**State Significant Development SSD 13855453
Request for comment - Grenfell Poultry Breeder Farm**

Thank you for providing the NSW Environment Protection Authority (EPA) with the opportunity to provide comment on the Environmental Impact Statement (EIS) for the proposed Grenfell Poultry Breeder Farm for Baiada Properties Pty Ltd at 1130 Gooloogong Road, Grenfell NSW 2810 (SSD-13855453; the Project).

ATTACHMENT 1: DETAILED COMMENTS FROM REVIEW OF EIS

Figure 28: Predicted 1 second 99th percentile Odour Concentrations K = 2.2 (Astute Environmental Consulting, 2021)

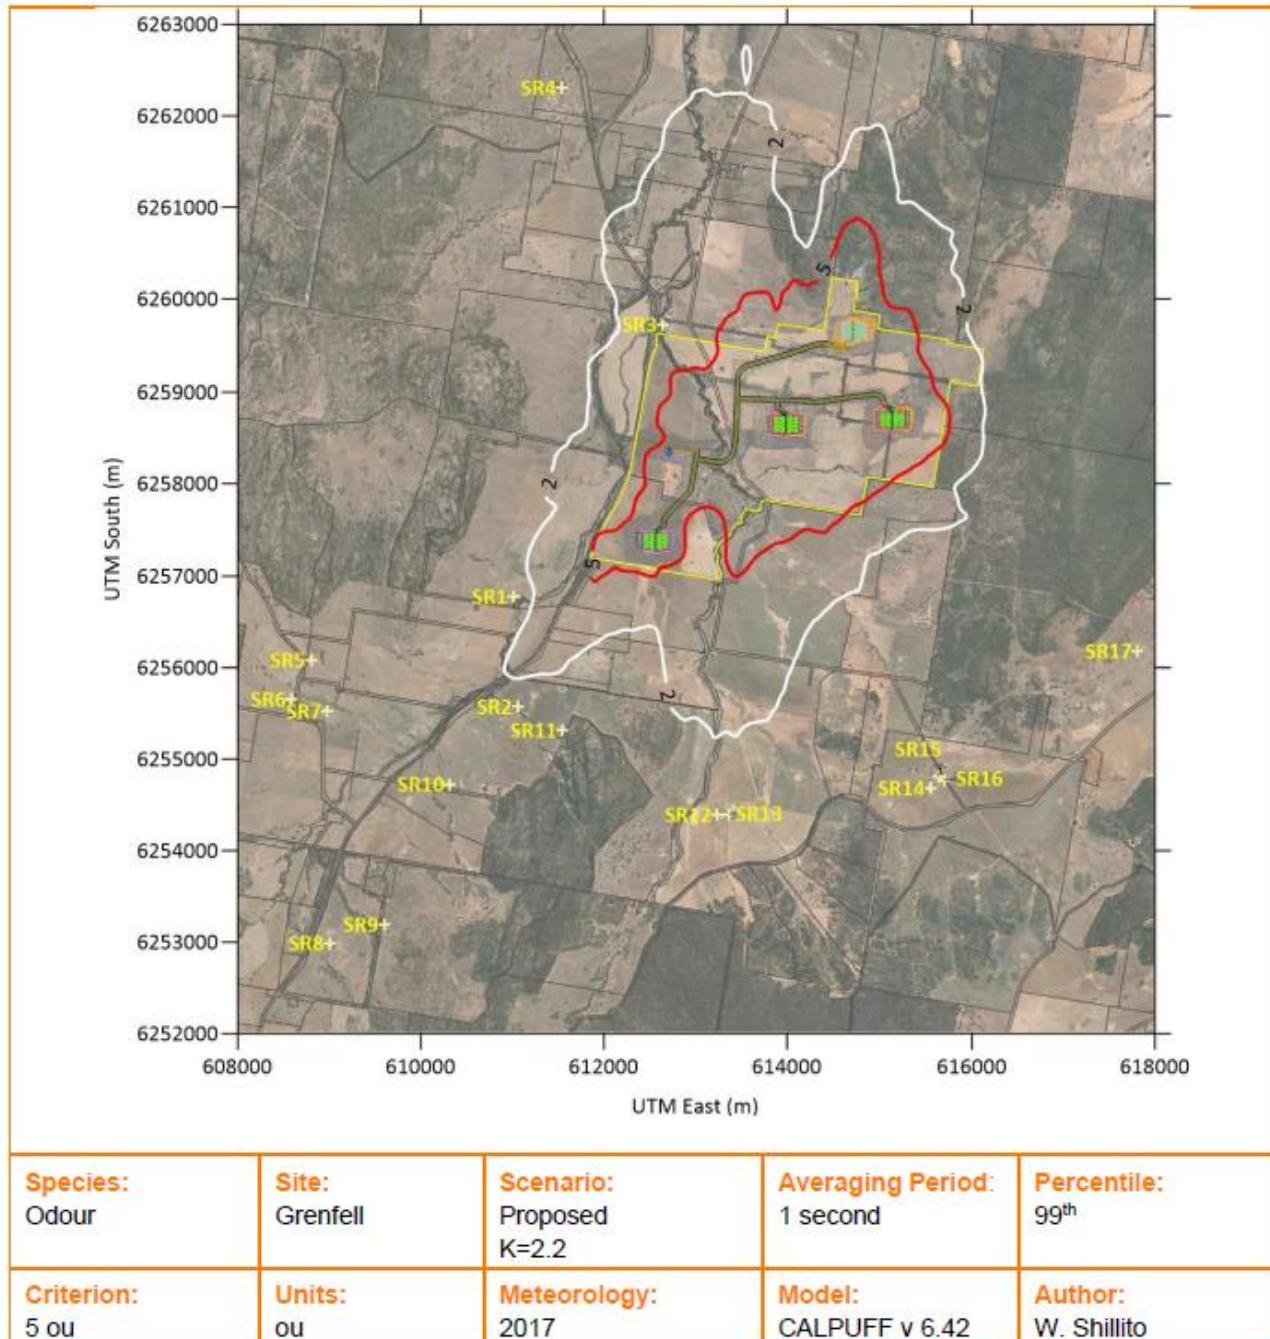
The Odour and Dust Assessment has modelled the four farms of 10 sheds each being stocked at day 1 of the calendar year. The modelling has assumed that a two-year period was simulated within a single year. However, it is unknown if this modelled bird placement regime results in the maximum odour emissions coinciding with the worst case meteorological conditions, which would represent worst-case odour impacts.

Although the proposed breeder/rearing farm will have a longer stocking regime than broiler farms, the odour modelling should include additional scenarios to ensure the prediction of worst-case odour impacts. These additional scenarios should assume a suitable offset period to account for variability of emissions and to model odour impacts over a greater set of meteorological conditions. The offset used to model broiler farms (i.e. 2 weeks) may not be suitable for breeder farms and the offset used should be adequately justified.

The EPA recommends that the proponent revises the modelling to include additional scenarios with offset stocking start dates to capture worst case impacts. Adequate justification for the assumed offset stocking dates must be provided.

Modelling of odour impacts in the Odour and Dust Assessment predicts less than 4 odour units (OU) at the nearest receptor. However, there is significant variability of odour emissions from the activities and only a limited staged stocking regime is modelled. These issues combined with the inherent uncertainty in odour modelling means the results presented do not provide for adequate evaluation of impacts and that no offensive odour beyond the boundary will occur.

The EPA recommends the proponent evaluates the odour risk of the activities and identifies additional reasonable and feasible mitigation and controls that could be applied should odour become an issue once the facility is operational. Consideration should be given to section 129 of the POEO Act concerning control of “offensive odour”.
